CITY OF ALBUQUERQUE

June 16, 2017

**Re: Del Webb @ Mirehaven Phase 2A
Request Pad Certification for lots 23-27, 29-33 – Accepted
Engineer's Stamp dated: 3-11-16 (H09D017F)
Certification dated: 6-14-17**

CITY PROJECT NO.	ZONE MAP NO.	SHEET	OF
		2	7

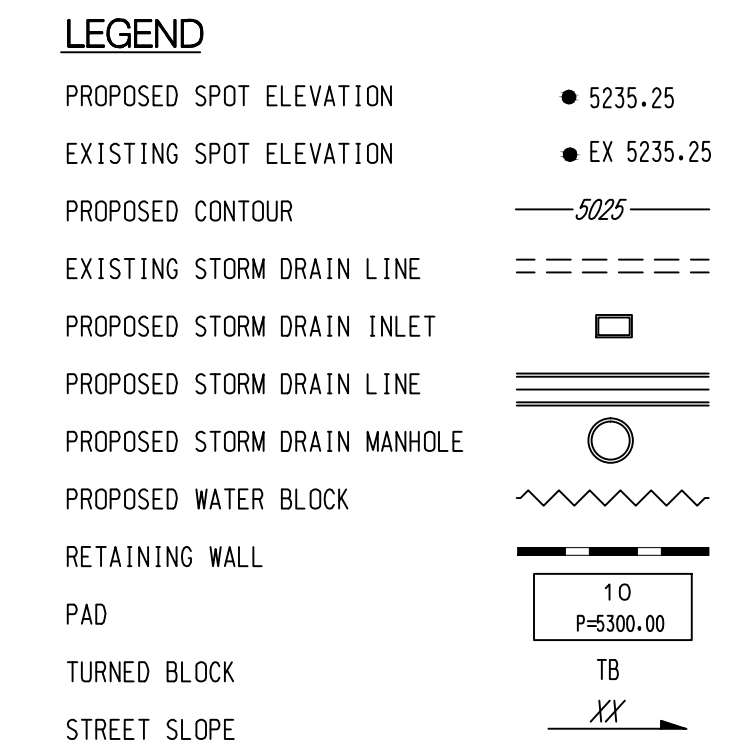
Based on the Certification received 6/14/17, the above referenced lots are approved for Pad Certification by Hydrology with the condition that a revised G&D plan be submitted to Hydrology for approval that shows the changed condition in the rear yards of 23-27 prior to Engineer's Certification for release of financial guarantees.
